**From:** Nicola Oktay on behalf of Planning.Responses  
**Sent:** 12 December 2024 10:40  
**To:** Planning Scanning  
**Subject:** FW: Planning Consultation on: BN/122/24/HH

**Application No:** BN/122/24/HH

**Site Address:** 43 Elm Grove Barnham PO22 0HL

**Description of Works:** Erection of front link attached garage and workshop with home office over.

FOR MR S. DOWNES		
SITE 43 ELM GROVE, BARNHAM, WEST SUSSEX. PO22 0HL		
TITLE PROPOSED GARAGE/ WORKSHOP ELEVATIONS		
SCALE 1:100	DRAWN AH 08/24	DRAWING NO. 04 REV

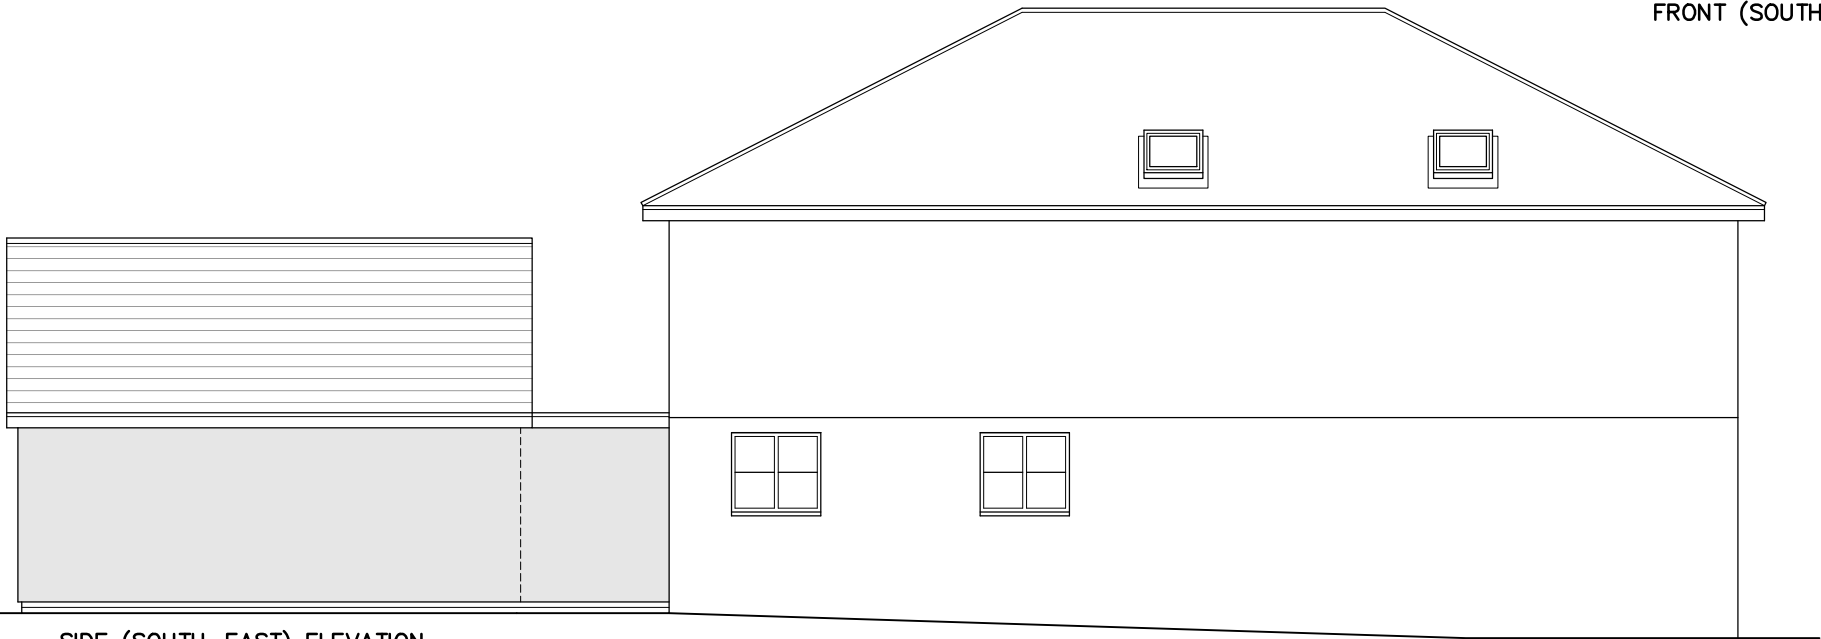
Furthermore, the committee would like to state that they are of the view that the proposed development extends beyond the front of the building line and is not in keeping with the local area, which is not in line with BEPC NP policy ES5 Quality of design, (full details below).

FOR MR S. DOWNES		
SITE 43 ELM GROVE, BARNHAM, WEST SUSSEX. PO22 0HL		
TITLE PROPOSED GARAGE/ WORKSHOP FLOOR PLANS		
SCALE 1:100	DRAWN AH 08/24	DRAWING NO. 02 REV A

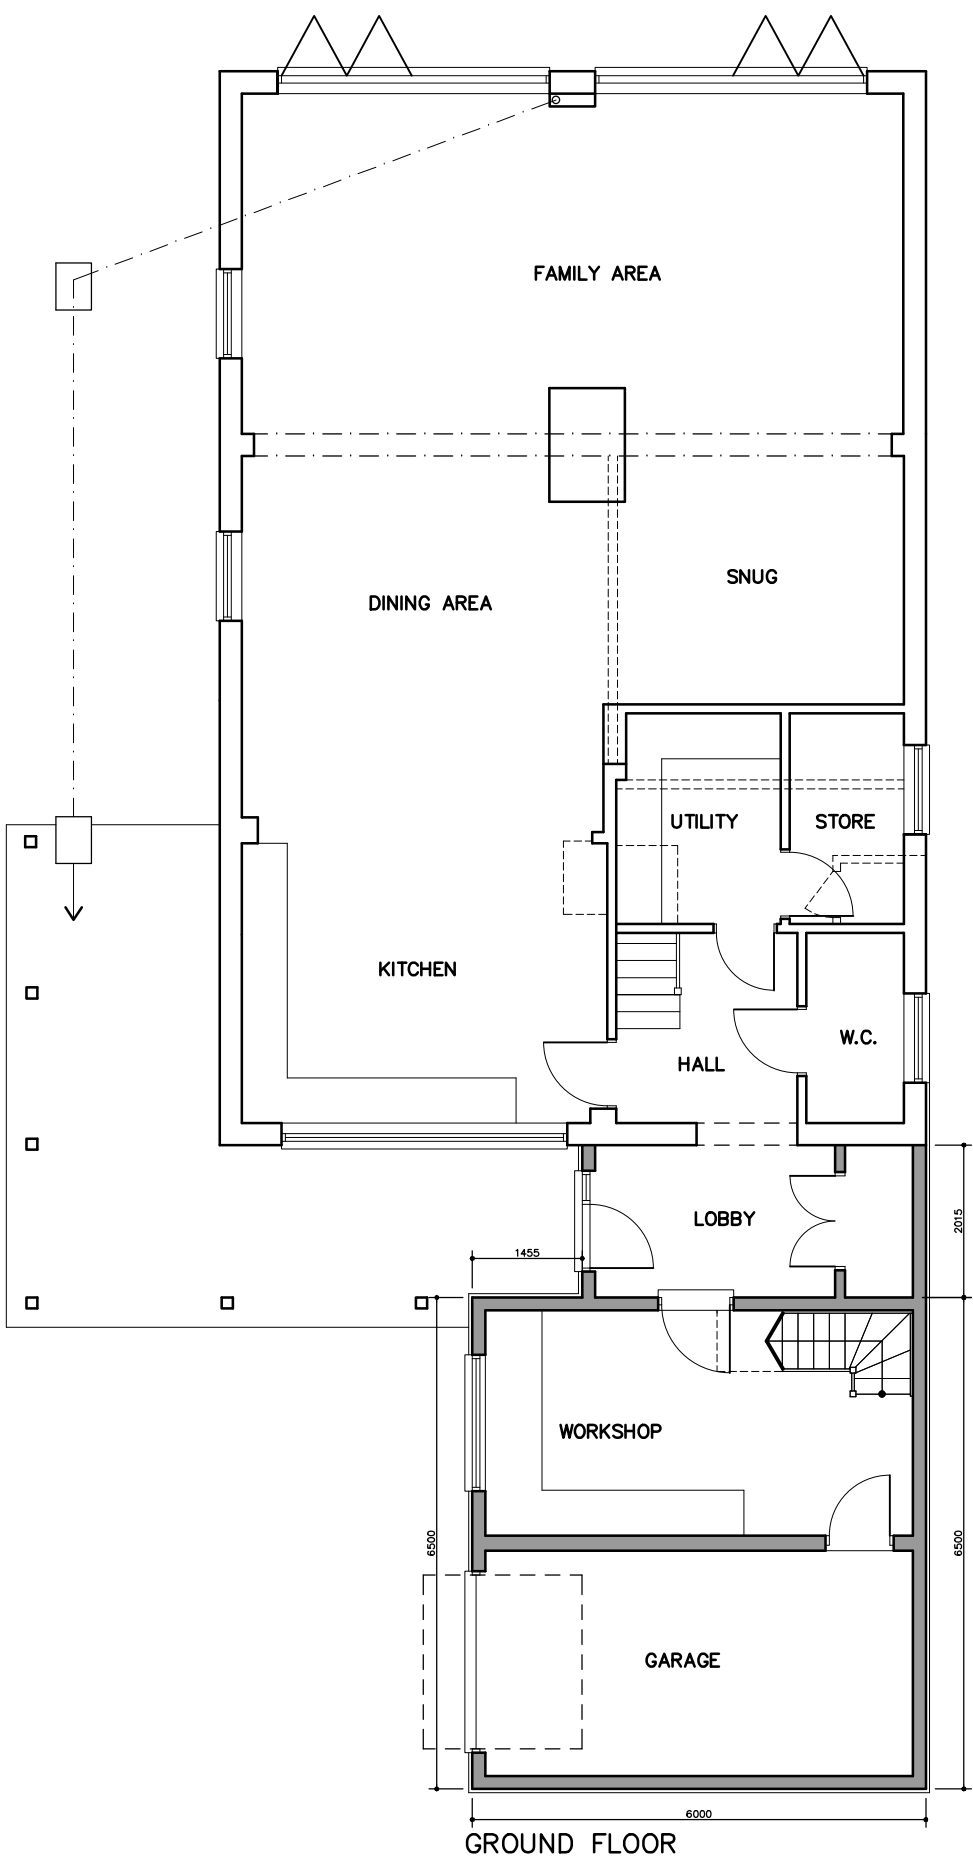
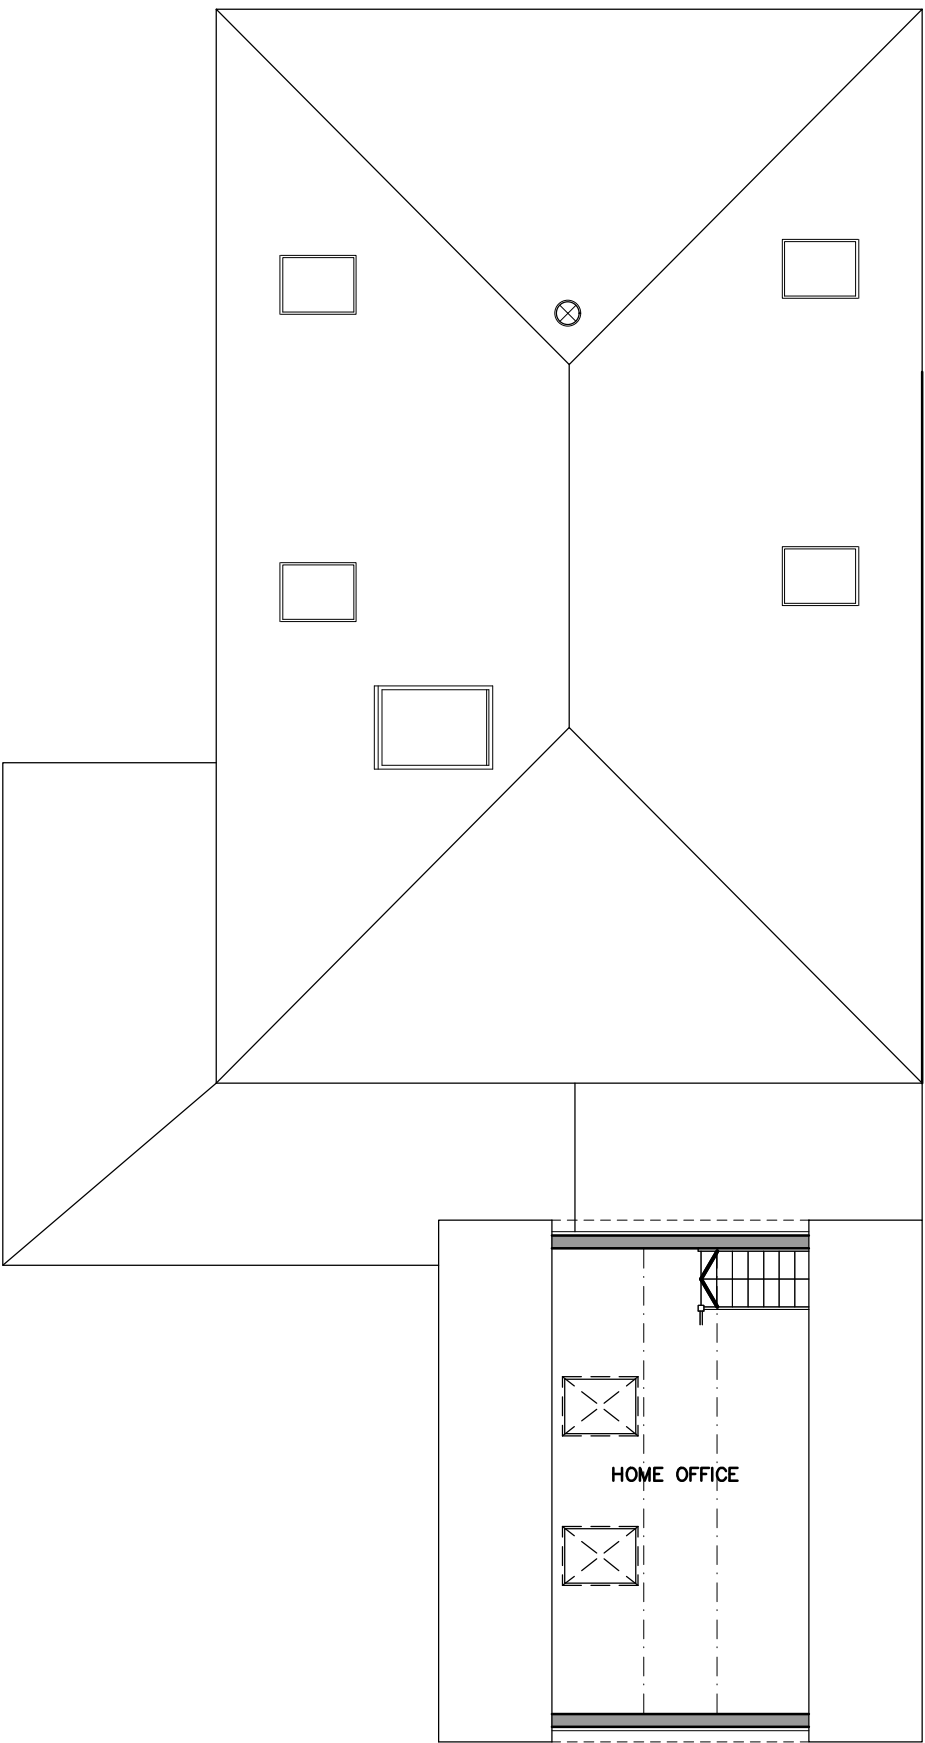
Due to the historic surface water drainage problems in this area, the committee are of the view that the proposed development, which would be built over the existing permeable drive, would have a negative impact on the already insufficient system capacity. This is due to the surface water drainage system at Elm Grove joining to the trunk main from which there have been previous regular problems and goes against BEPC NP policy ES1c Sewage, (full details below).

The committee also considers that the proposed development has the potential to cause loss or adverse impact to existing trees and hedgerows, which goes against BEPC NP policy ES10 Trees and Hedgerows, (full details below).
